WEST SUSSEX COUNTY COUNCIL CONSULTATION

TO:	Arun District Council FAO: Ms Myer
FROM:	WSCC - Highways Authority
DATE:	22 December 2021
LOCATION:	Land between 32 Downs Way and 2 Ambersham Crescent Angmering BN16 1AB
SUBJECT:	A/253/21/1/OUT Outline planning application with all matters reserved for the erection of 1 No bungalow dwelling with off street parking and private amenity space.
DATE OF SITE VISIT:	n/a
RECOMMENDATION:	Advice
S106 CONTRIBUTION TOTAL:	n/a

Indicative Plans and Elevations

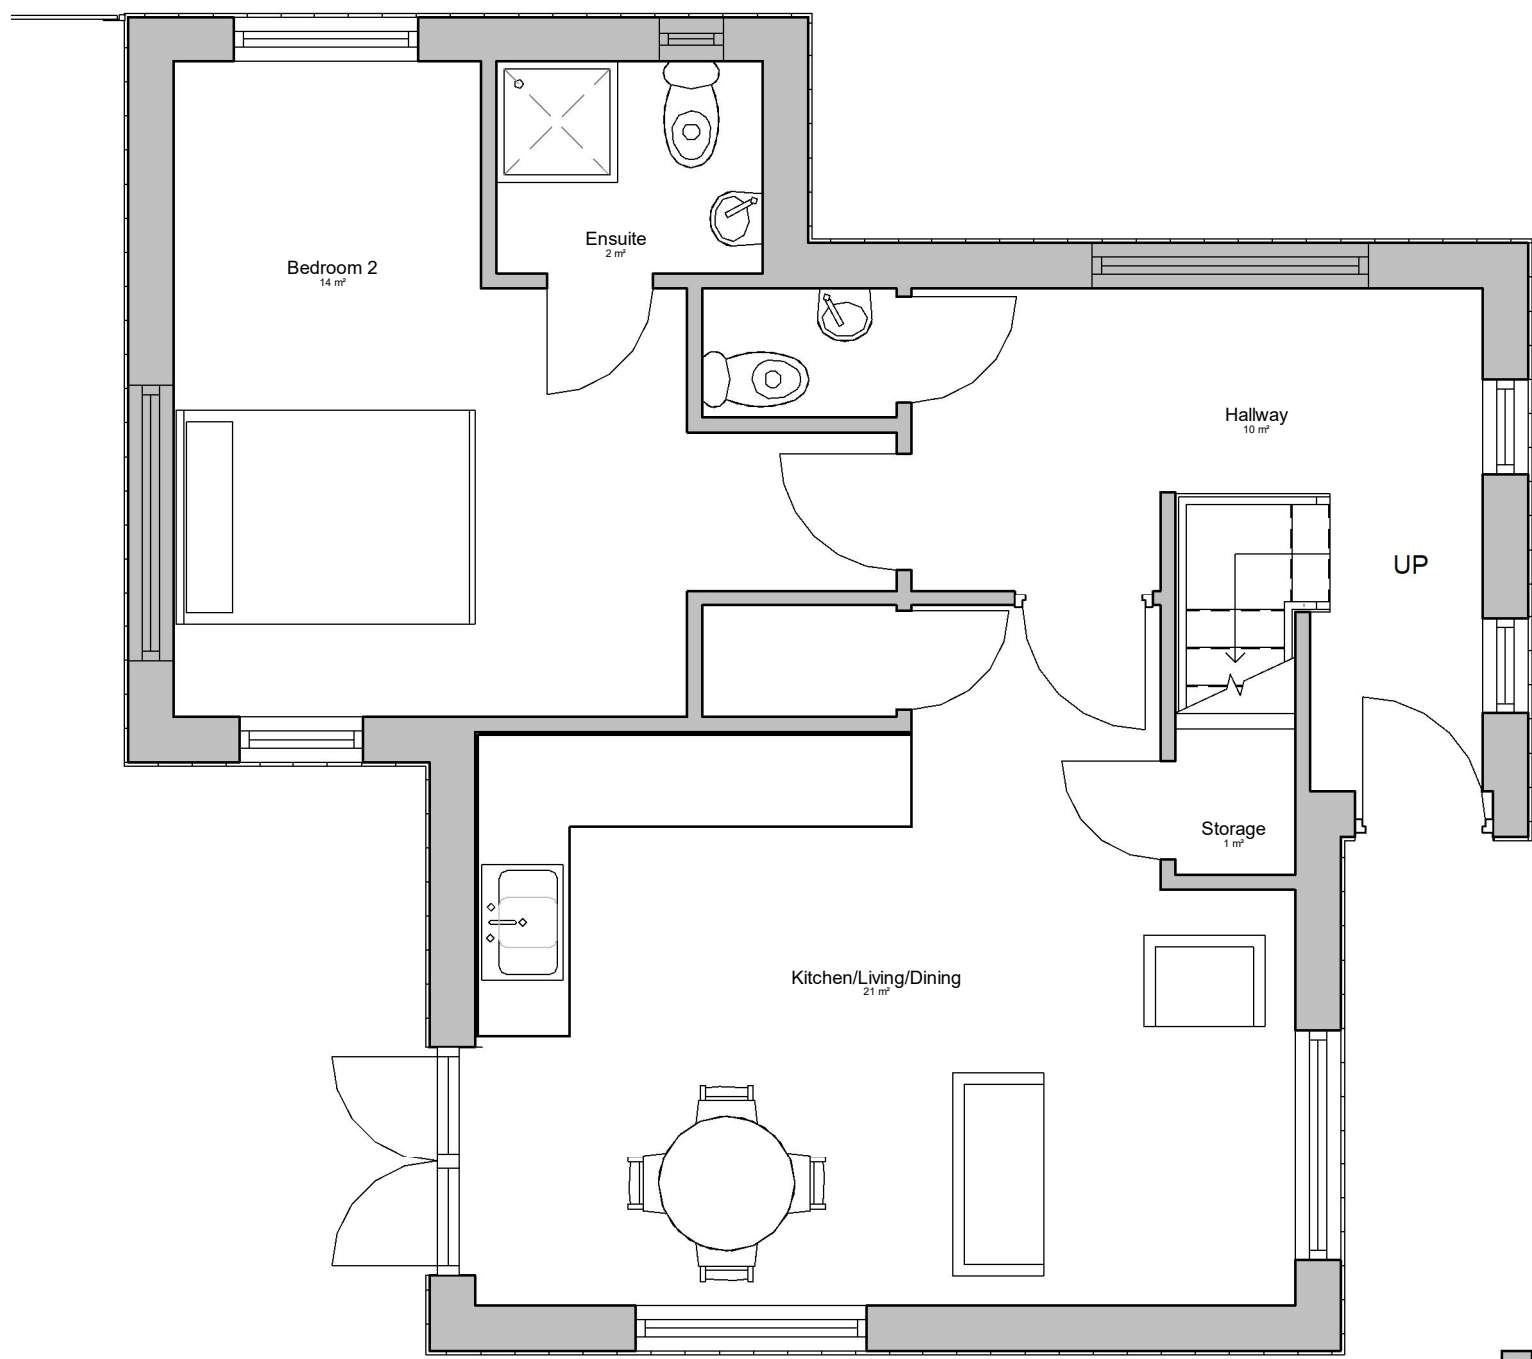
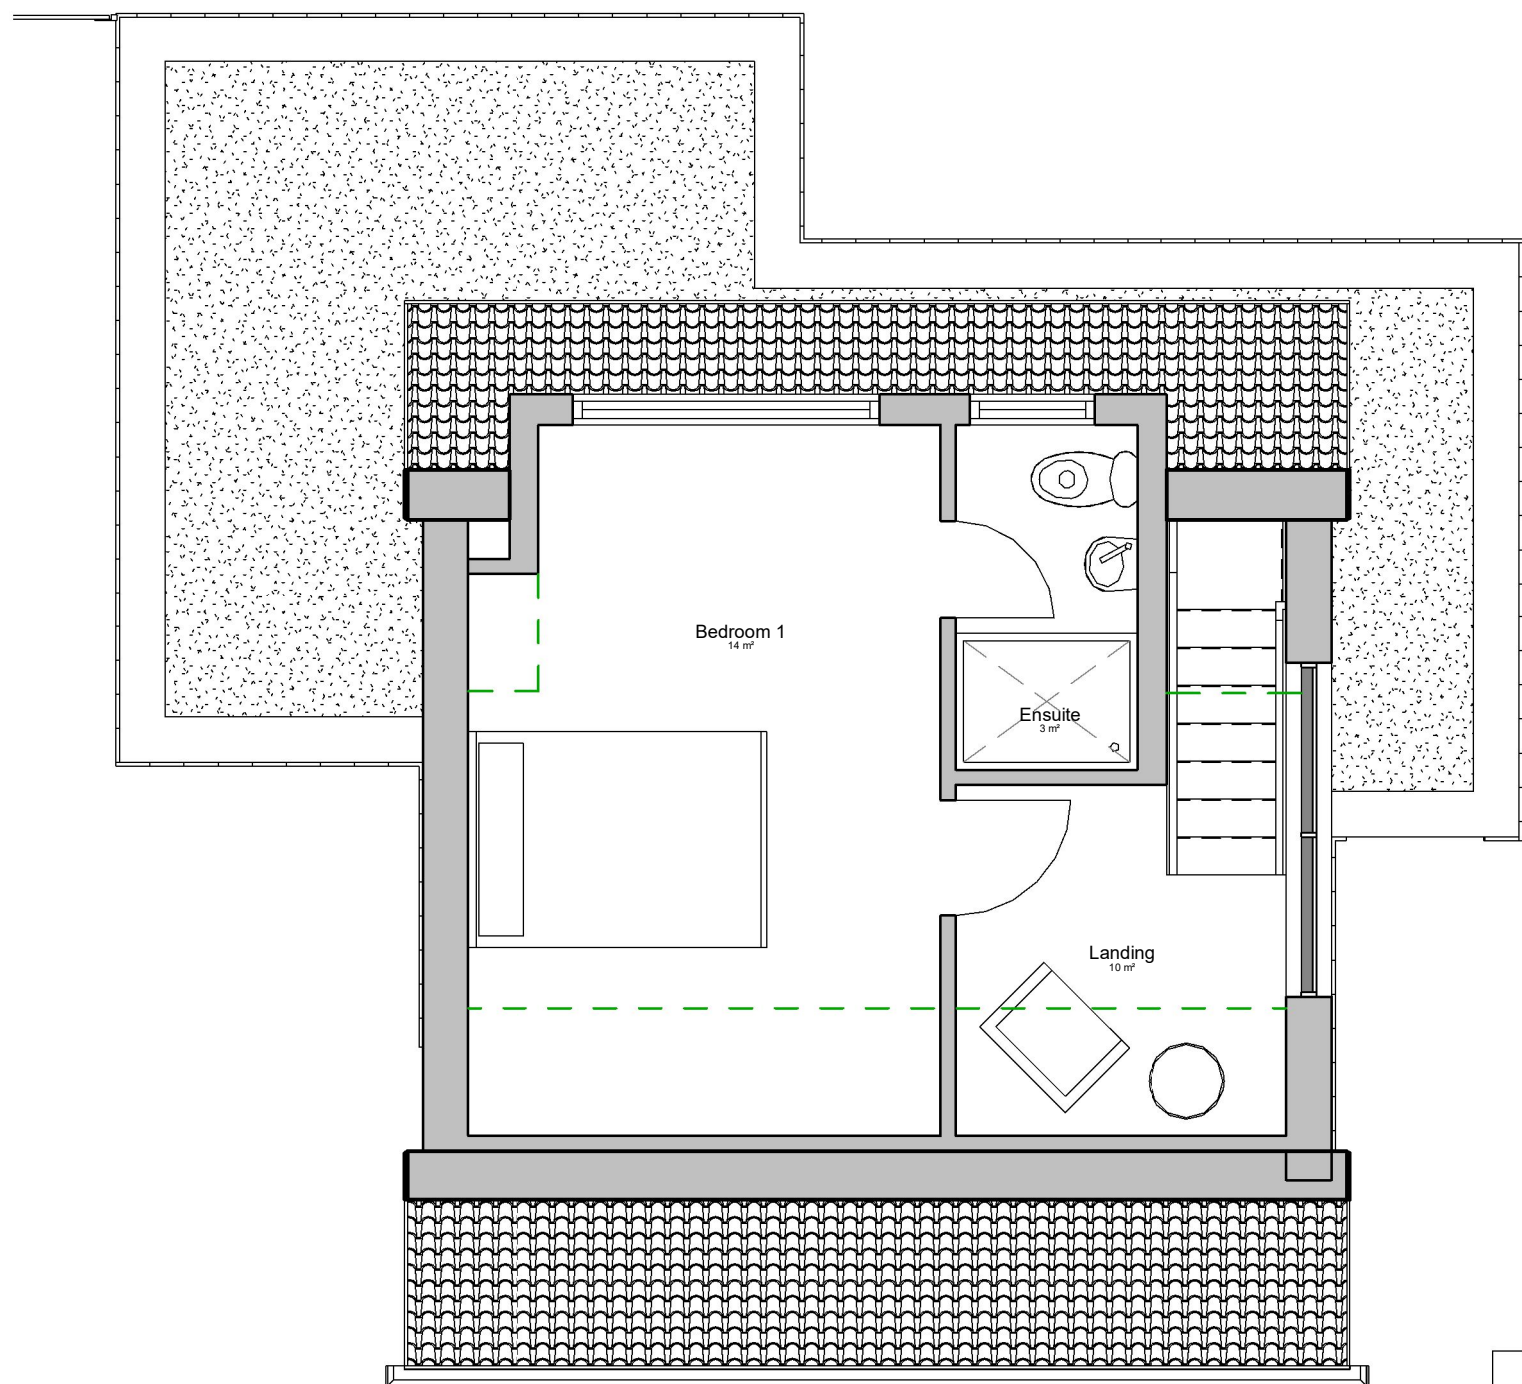
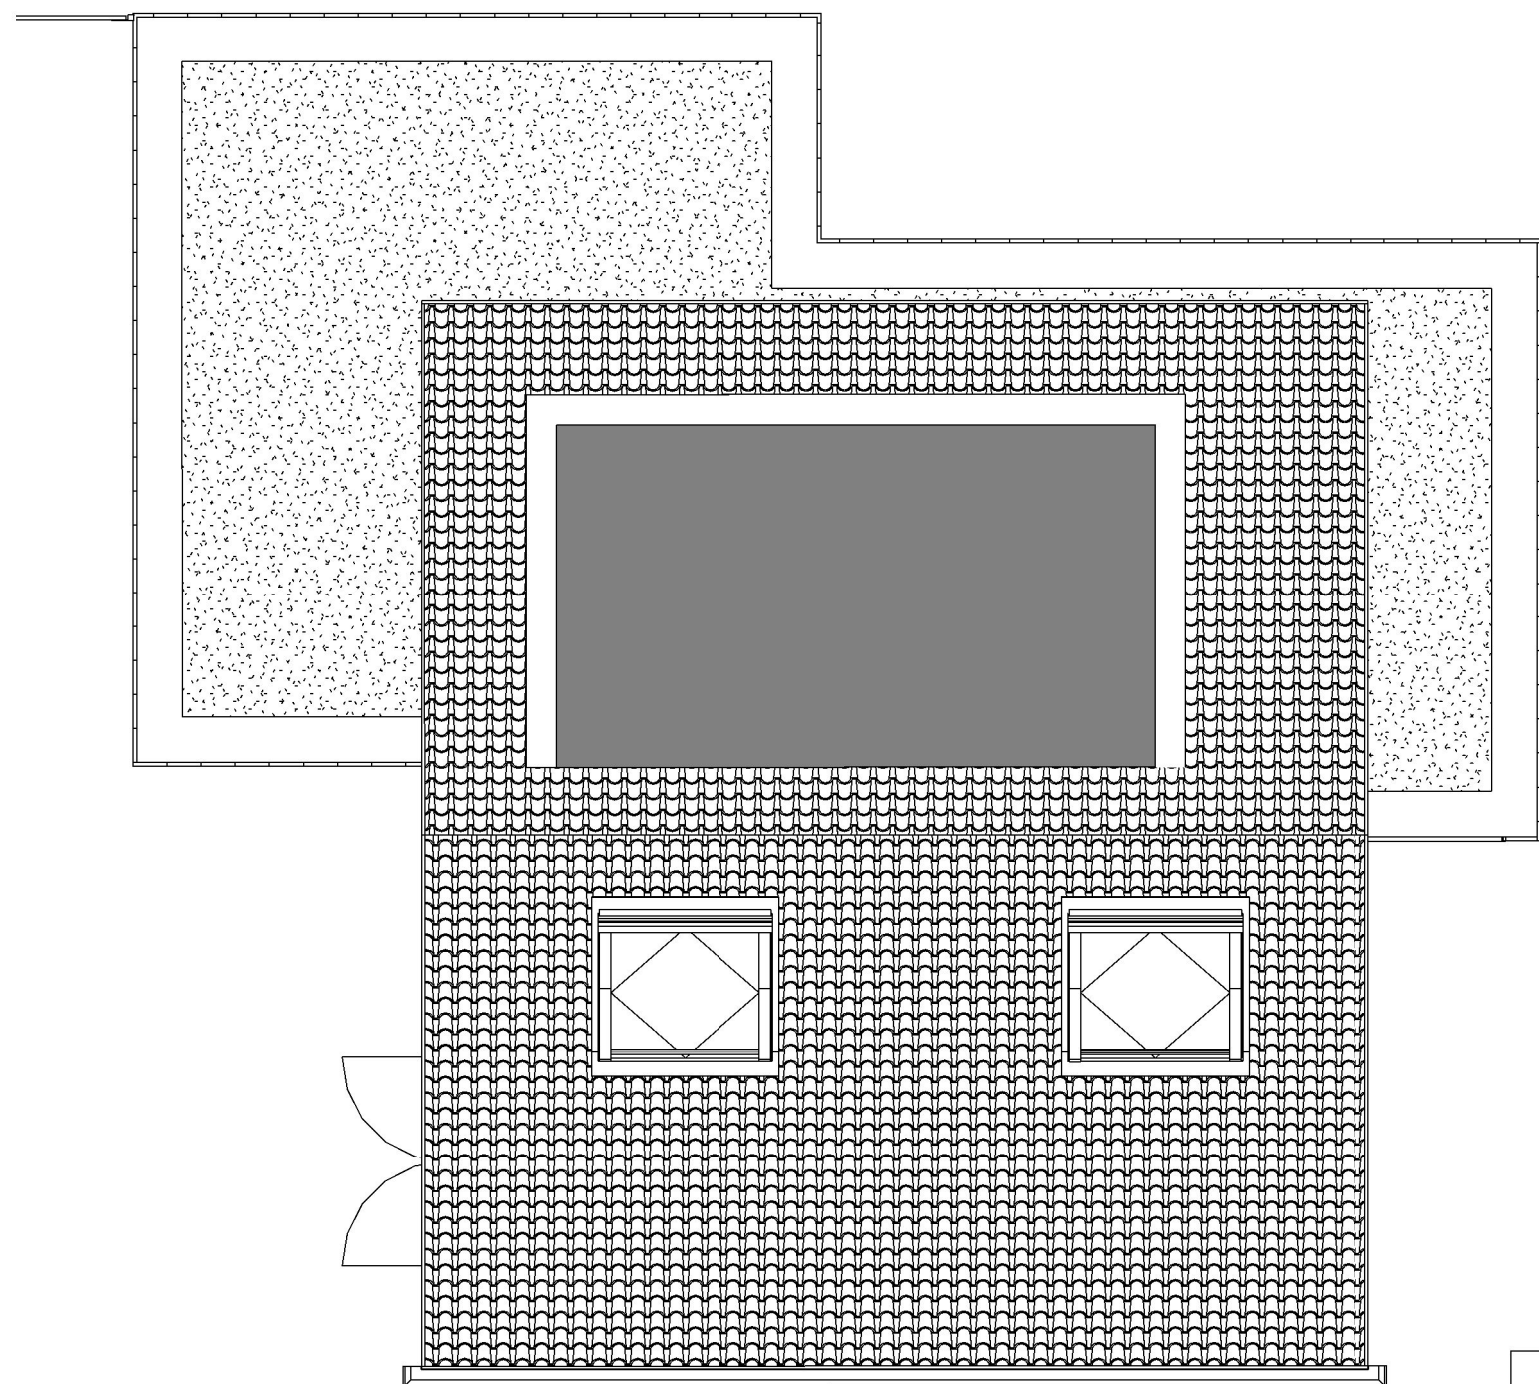
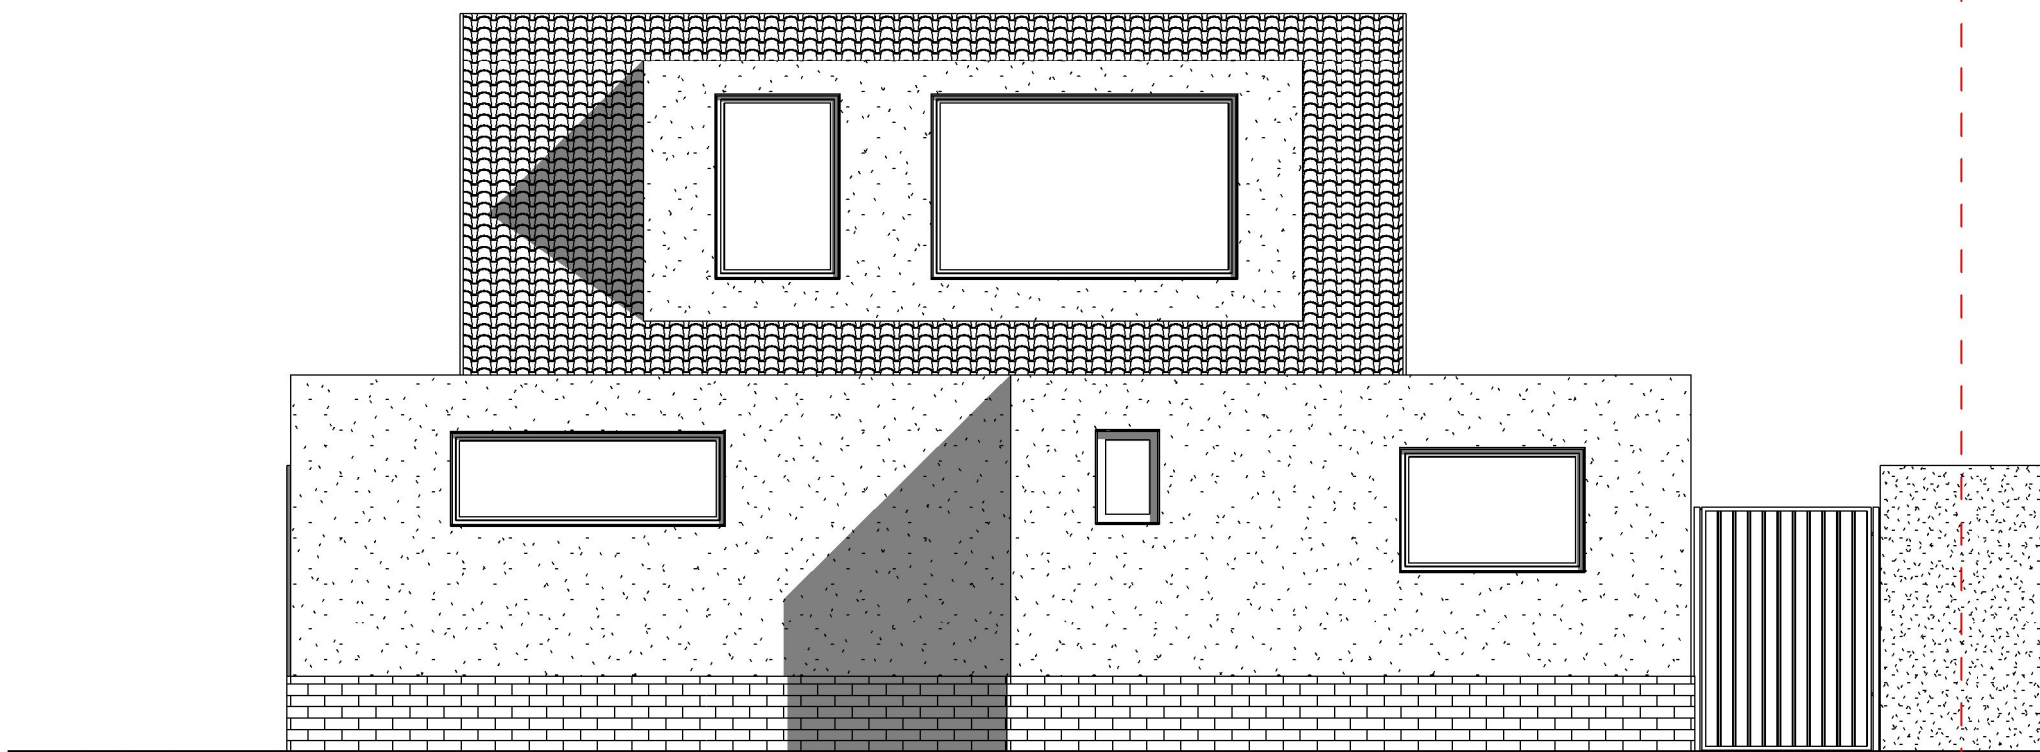
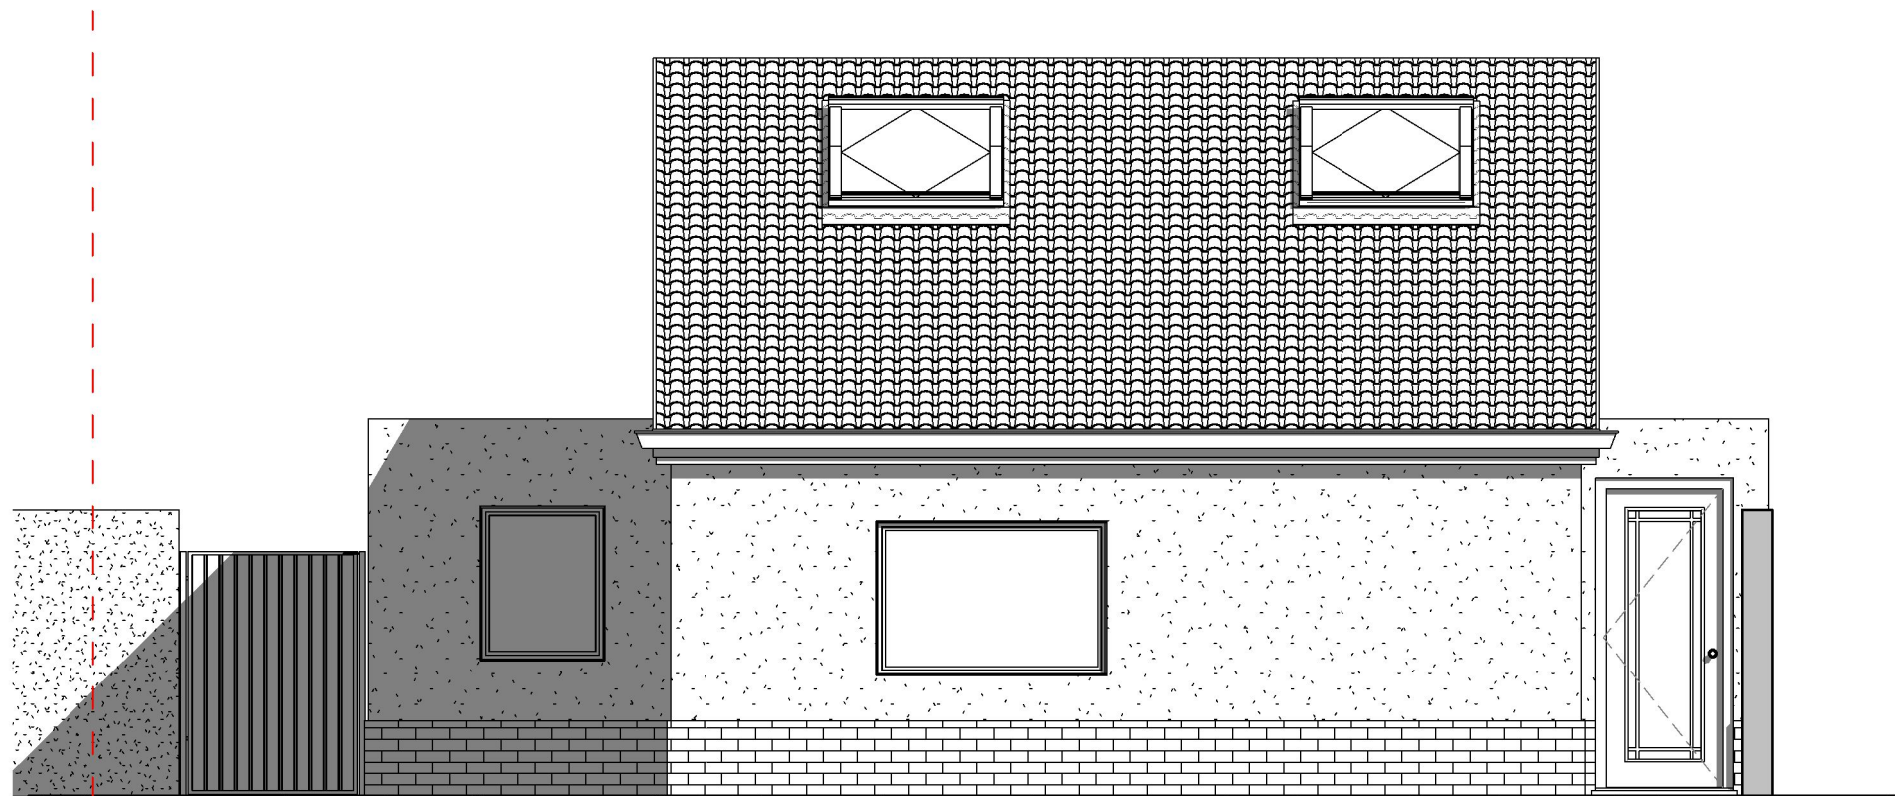
The indicative plans provided detail that the application site, and indicative physical build, is on land considered public highway. As such in order to not result in a physical obstruction to the extent of public highway and be subject to enforcement action the land required to implement the application will need to be first Stopped Up.

An internal 'in principle' consultation process has taken place and it has been concluded that Stopping Up would not be supported by WSCC because the land provides an important public amenity and there may also be services and other highway assets underneath that require access for maintenance.

The applicant is therefore strongly advised to take this into consideration when it comes to further developing and proceeding with this application. The Local Highway Authority want to make their view on this matter clear at this stage so the applicant is fully aware that if permission is granted it seems extremely unlikely, based on the plans and details submitted to date, that the Stopping Up which would be required to implement the scheme will be granted.

The applicant is advised that the existing public highway to be incorporated into the development must be the subject of a Stopping Up Order. This process must be successfully completed prior to any highway land being enclosed within the development. The applicant should contact the Department for Transport's National Transport Casework Team in order to commence this process:

The applicant is advised that based on the plans and details submitted to date it is considered extremely unlikely that the Stopping Up which would be required to implement the scheme will be granted.
